# DRB CASE ACTION LOG (PREL & FINAL)

DRB Application No.: 07DRB-70288

Project # 1006733

Project Name: **OLD TOWN GARDENS ADDITION**

**PLAT OF
TRACTS A, B AND C
OLD TOWN GARDENS ADDITION
PROJECTED SECTION 14, T. 10 N., R. 2 E., N.M.P.M.
TOWN OF ALBUQUERQUE GRANT
CITY OF ALBUQUERQUE
BERNALILLO COUNTY, NEW MEXICO
SEPTEMBER 2007
SHEET 2 OF 2**

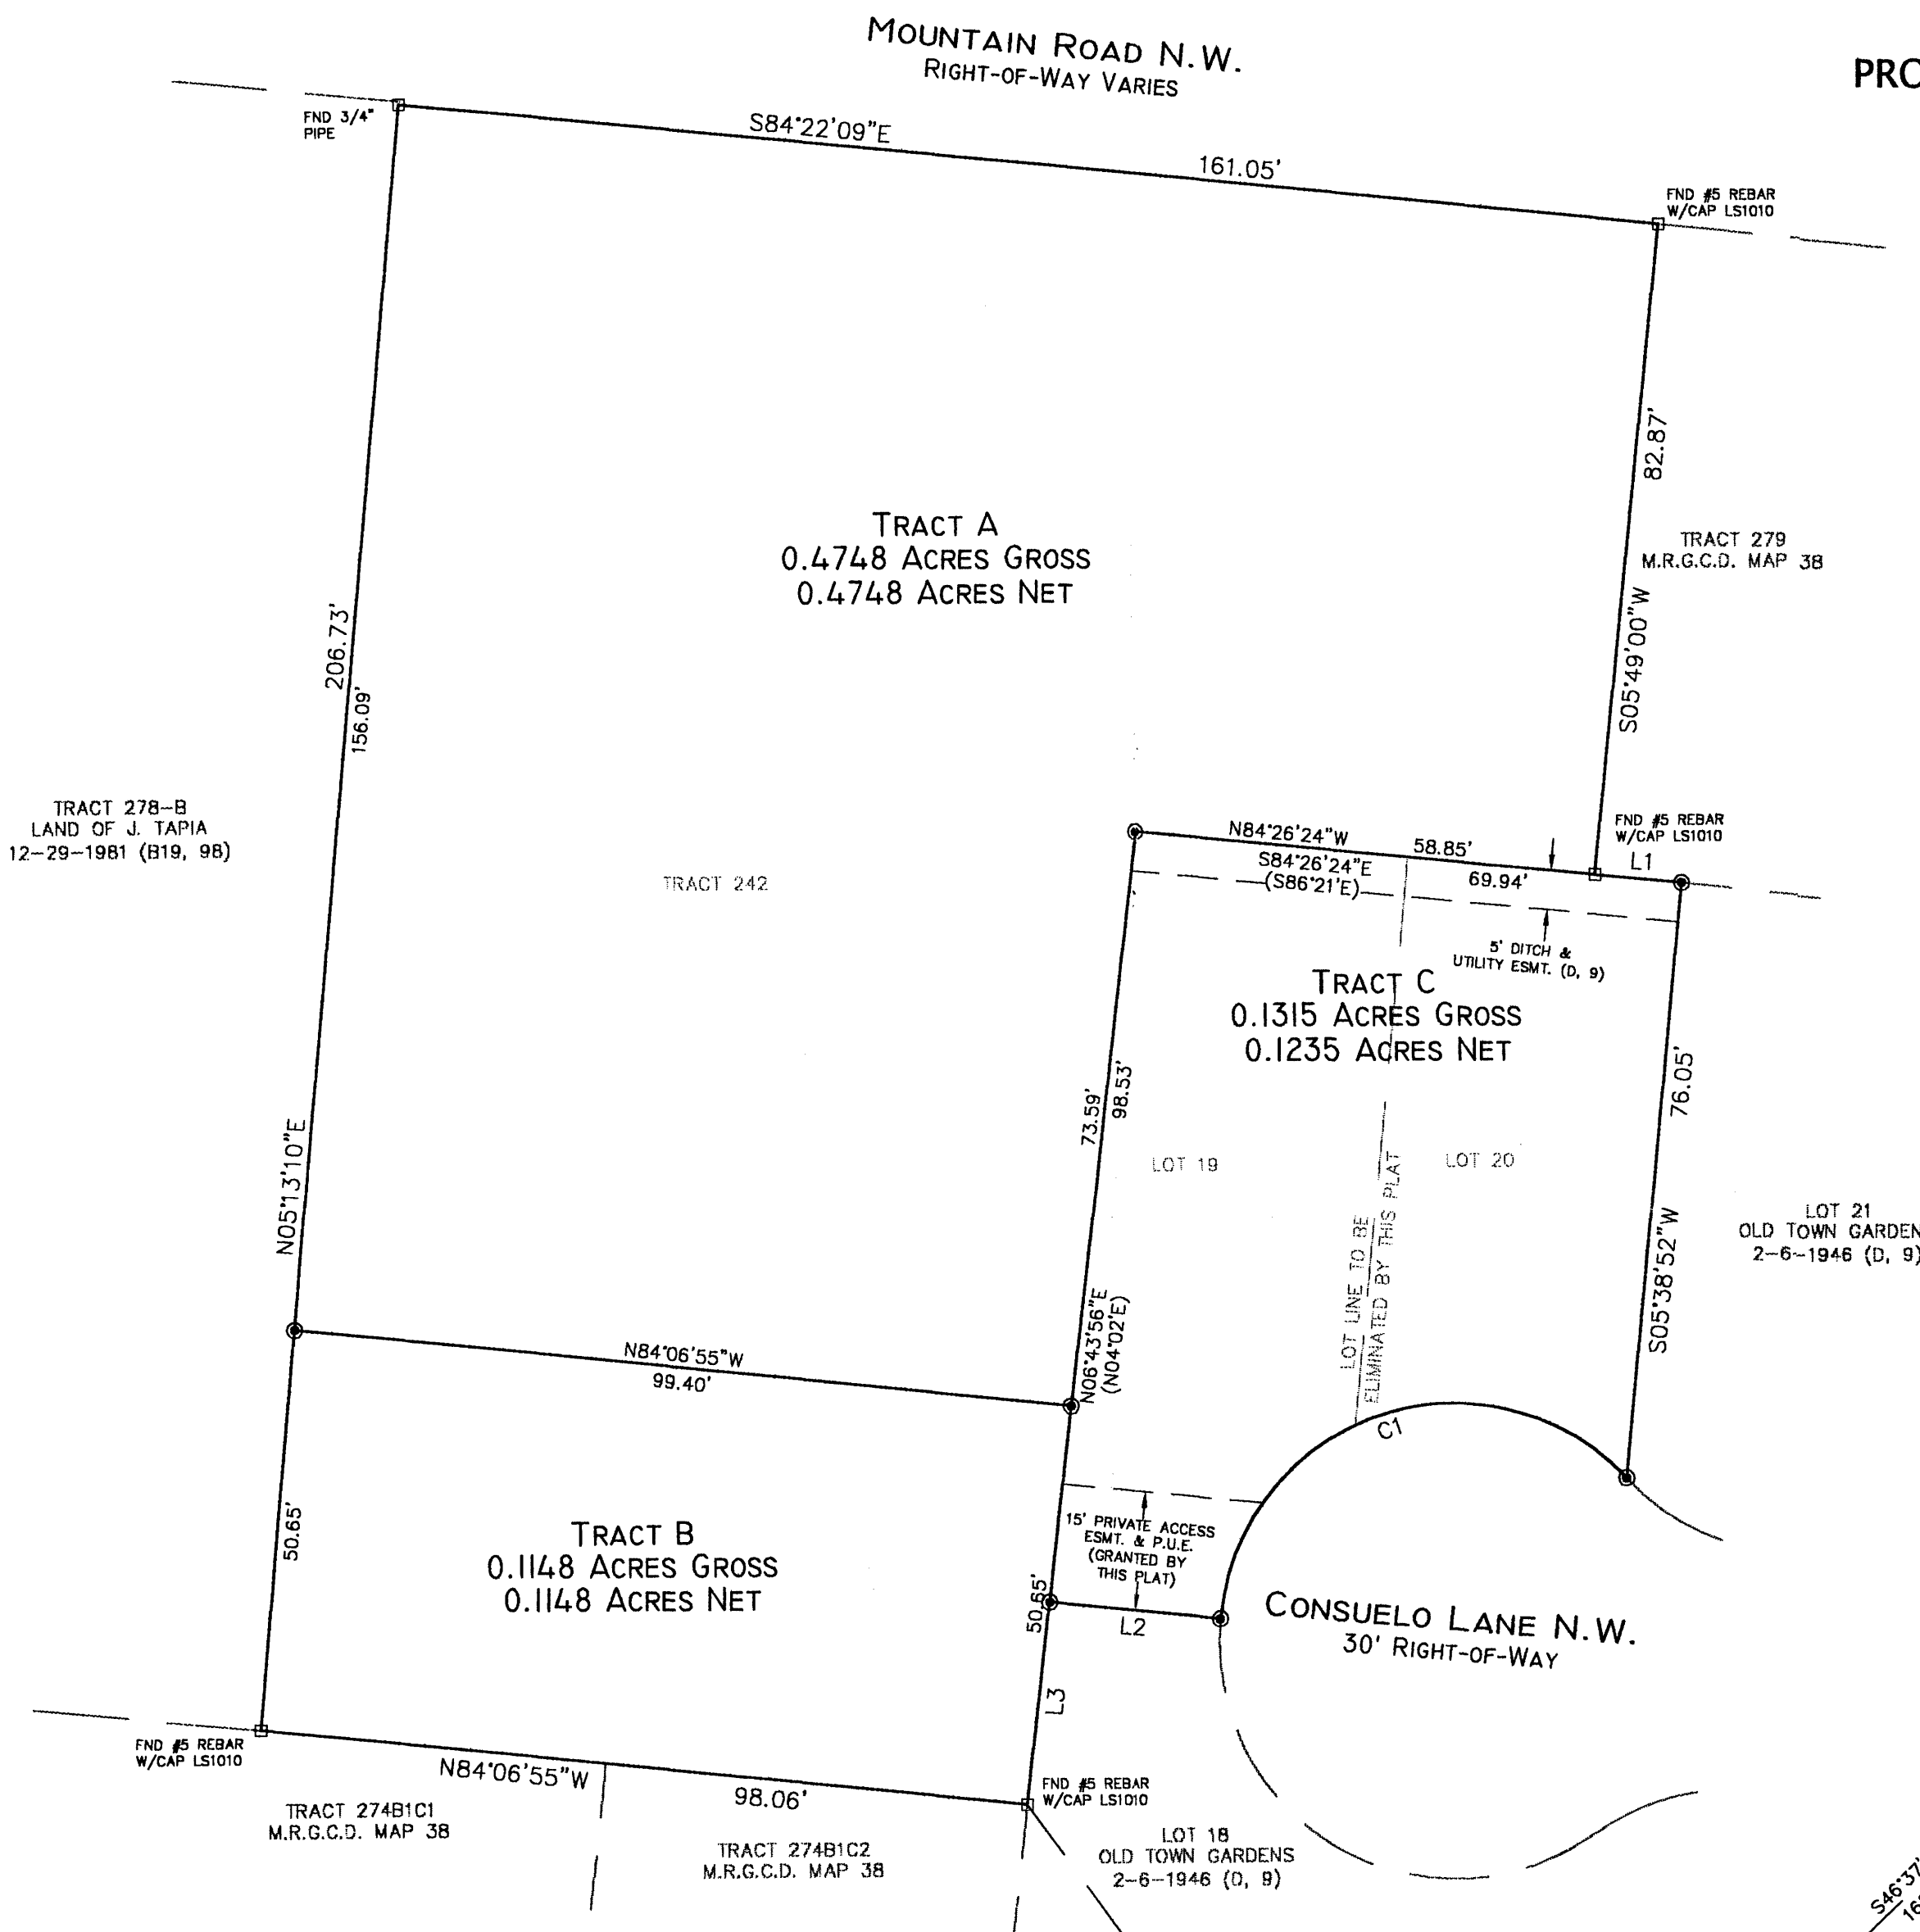
TRANSPORTATION: dedicate sidewalk (construct sidewalk)

A cross lot drainage easement is required.
